Proposed A14 (Cambridge to Huntingdon Improvement) Development Consent Order ("the Application")
Planning Act 2008
Infrastructure Planning (Examination Procedure) Rules 2010
Network Rail Infrastructure Limited ("Network Rail")
Unique Reference Number: 10031042

**APPLICATION FOR THE A14 (CAMBRIDGE TO HUNTINGDON IMPROVEMENT) DEVELOPMENT
CONSENT ORDER (Reference TR10008)**

**WRITTEN REPRESENTATION OF NETWORK RAIL INFRASTRUCTURE LIMITED
(Unique Reference Number 10031042)**

Drawing file: TR010018 / TR010018-000389-A14 2.03 Land Plan-Sheet 28 of 40.pdf

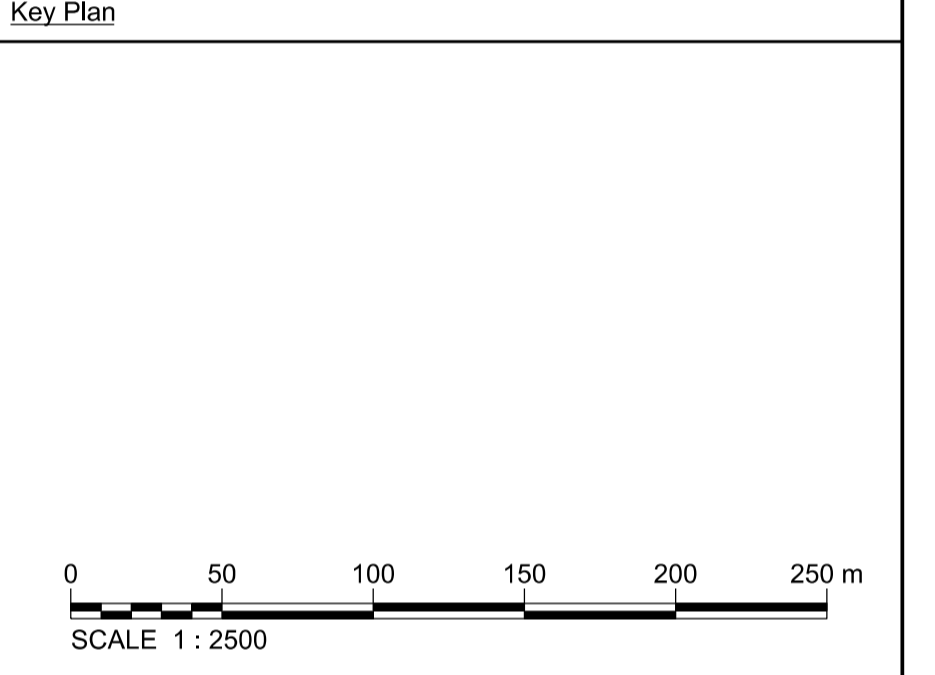
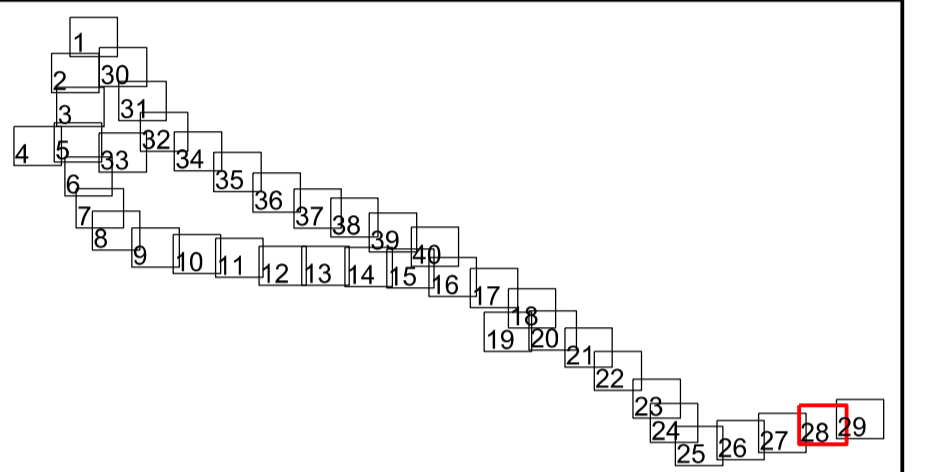
ECHR	The European Convention of Human Rights
Existing Access	The existing access road into Huntingdon Station from Brampton Road
Land Plans	The land plans submitted with the Application
Network Rail	Network Rail Infrastructure Limited
Network Rail Land	Plots 9/7, 9/8, 9/9, 9/16b, 34/30, 34/31a, 34/32a, 34/32b, 34/32d, 34/35a, 34/35b and 34/36 in the Book of Reference
Network Rail Rights Land	Plots 34/25b, 34/25d, 34/25e, in the Book of Reference
New Bridge	The proposed new bridge over the East Coast Main Line on the New Bridge Land being Work 5(jj) in the Draft DCO
New Bridge Land	Plot 9/16b in the Book of Reference as shown on Sheet 9 of the Land Plans
New Northern Access	The proposed new access to Huntingdon Station to the east of the East Coast Main Line being Work 36(b) in the Draft DCO shown as New Private Means of Access Number 5 on Sheet 28 of the Rights of Way and Access Plans
New Southern Access	The proposed new access to Huntingdon Station to the east of the East Coast Main Line being Work 36(c) in the Draft DCO shown as New Private Means of Access Number 6 on Sheet 28 of the Rights of Way and Access Plans

- (g) The Existing Access provides the only vehicular access to the eastern platforms of Huntingdon Station and the adjacent car parks. The permanent acquisition of the Existing Access pursuant to the DCO would prevent such access. Although powers are being sought in the Draft DCO for the provision of replacement access (ie the New Northern Access and the New Southern Access) there is no certainty that such accesses will be provided and, even if they are, there is no certainty that they will be provided before the closure of the Existing Access (see Section 4.5 below). The permanent acquisition of the North Eastern Car Park together with the temporary acquisition of the Existing Access would also lead to a position where inadequate parking facilities are provided at Huntingdon Station. No replacement car park is being provided under the scheme and Section 127(3)(b) is not therefore engaged. The taking of the New Southern Access Land would prevent access from being taken along this route unless and until a new access road is provided and suitable rights granted, and as stated above, the provision of these works and their timing is not guaranteed under the Order (again see Section 4.5 below). Moreover, the Water Tank Land, over which powers of temporary possession for up to six years are being sought, immediately adjoins New Southern Access Land. Even if the New Southern Access is constructed and made available for use, the temporary possession powers being sought over the Water Tank Land mean that there is no guarantee that access could in fact be taken. These powers of compulsory acquisition would severely disrupt the operation of Huntingdon Station and would therefore cause serious detriment to the carrying on of Network Rail's undertaking.

- 4.5.1 The Draft DCO authorises the compulsory acquisition of the Existing Access. The Existing Access provides the only vehicular access to the eastern side of Huntingdon Station including car parks and taxi drop-off points and if the scheme is implemented this access would cease to exist.
- 4.5.2 The Draft DCO does make provision for the replacement access to be provided in the form of the New Northern Access and the New Southern Access. However the Draft DCO does not provide adequate protection in this regard for the following reasons:
- (a) No provision is made to compel the Undertaker to construct the New Northern Access or the New Southern Access .

- (d) Although it is proposed that a private access is built to the station across Plot 34/36 to provide the New Southern Access, there is no guarantee that Network Rail will have any rights over that access. Plot 34/36 is being compulsorily acquired from Network Rail who would not appear to have any rights to use the land thereafter. The same principles apply to the New Northern Access.
